Case Ref: 21/01630/OUT

From: Emma Lawson – Newt Officer, NatureSpace Partnership

Response: **Further information required**

This Outline planning application is for residential development (within Use Class C3), open space provision, access, drainage and all associated works and operations including but not limited to demolition, earthworks, and engineering operations, with the details of appearance, landscaping, layout and scale reserved for later determination. The site is located at Land at north west Bicester, Home Farm, Lower Farm and SGR2 Caversfield.

Site Location TITLE

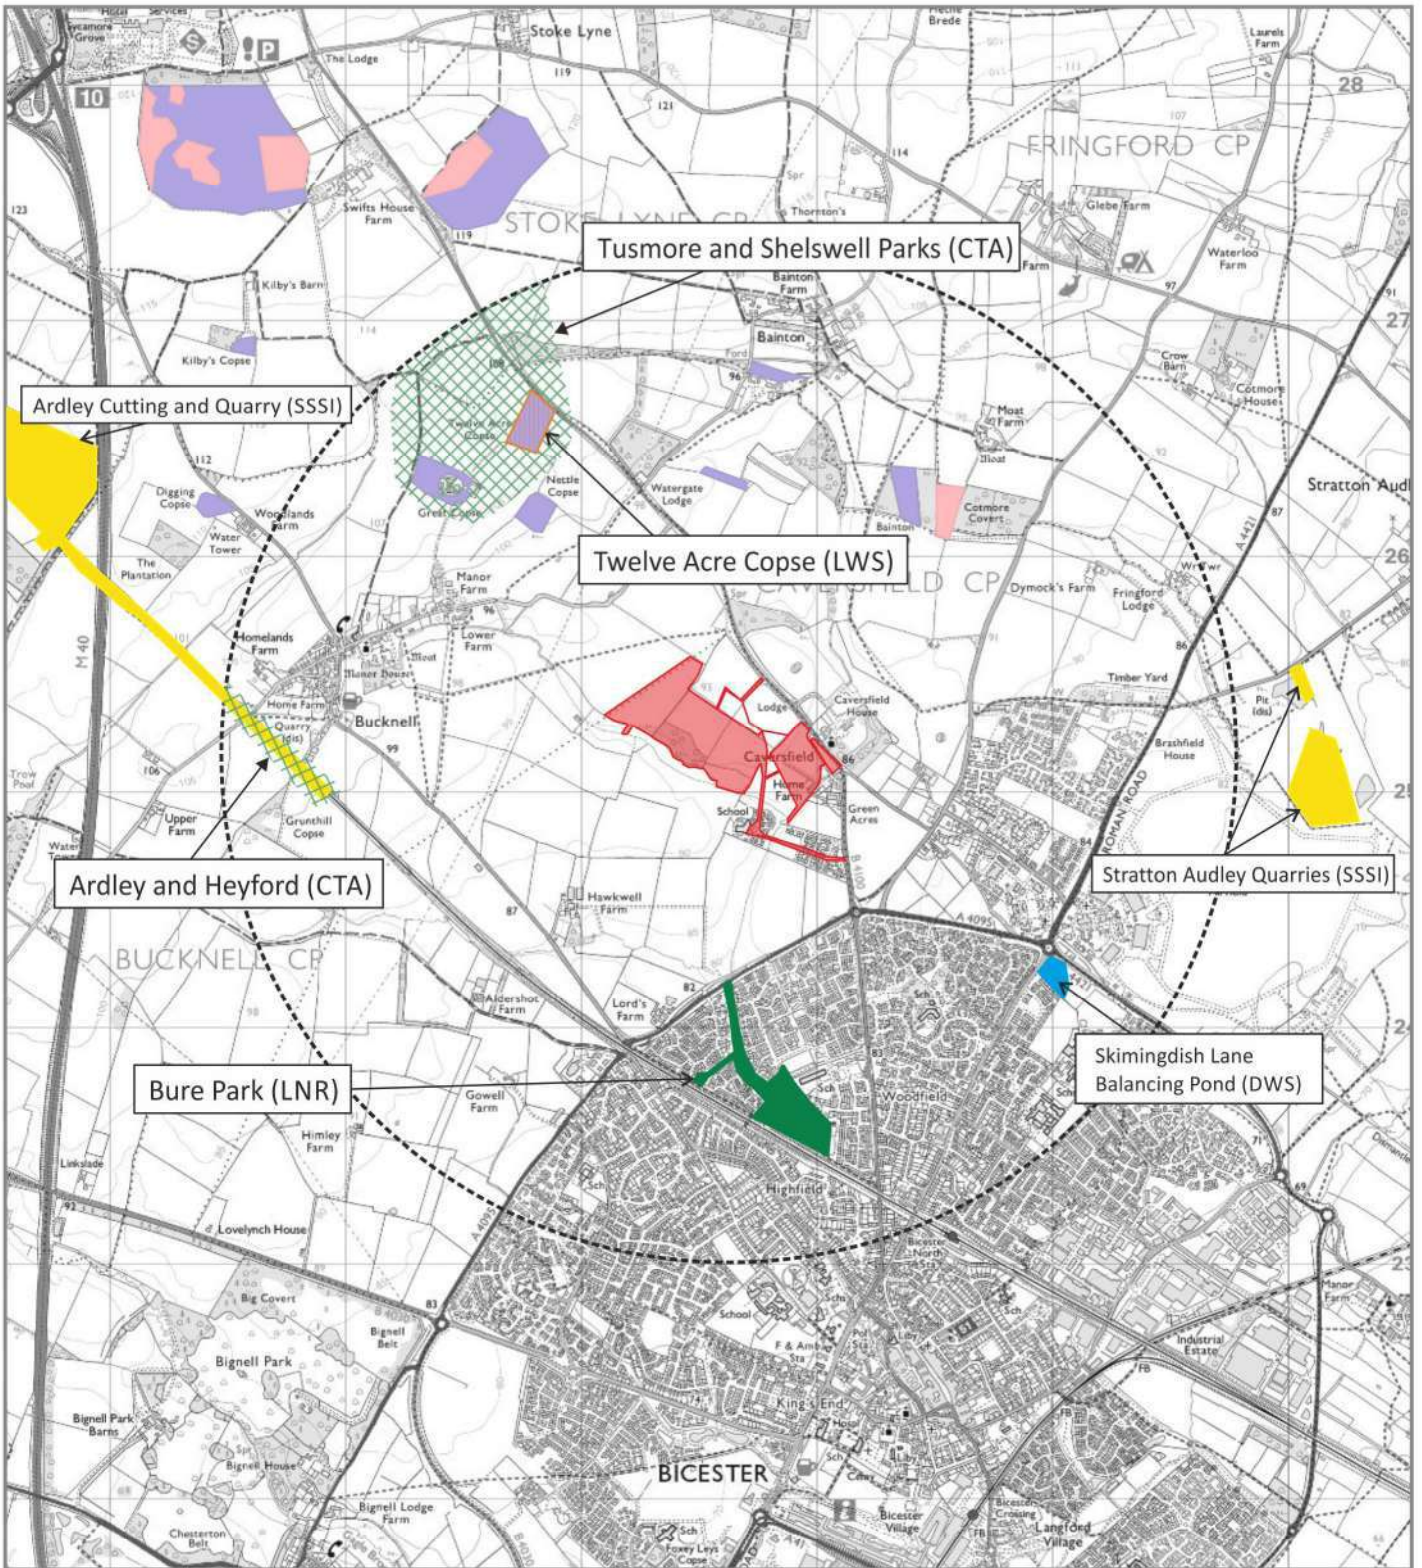
- Aerial imagery shows a large pond, and a subsequent smaller one adjacent to it, situated less than 50m from the East boundary of the site at Caversfield House, which has not been included in the Preliminary Ecological Appraisal and subsequent investigations in relation to GCN presence such as HSI of the pond and eDNA. Previous comments on neighbouring planning applications (see 13/01056/OUT, Public Comments, 12/08/2013, Kleinman D 9.8.13) raised GCN as a consideration there too. These ponds are also shown on the submitted Location plan, Drawing 001, dated 14/04/2021.

- Provide an updated ecological assessment of the site and surrounding landscape to further assess the likely presence/absence of GCN; or
- Submit a NatureSpace Report/Certificate to confirm the proposed development is capable of being covered by the Council's District Licence and the applicant has entered the District Licensing Scheme.
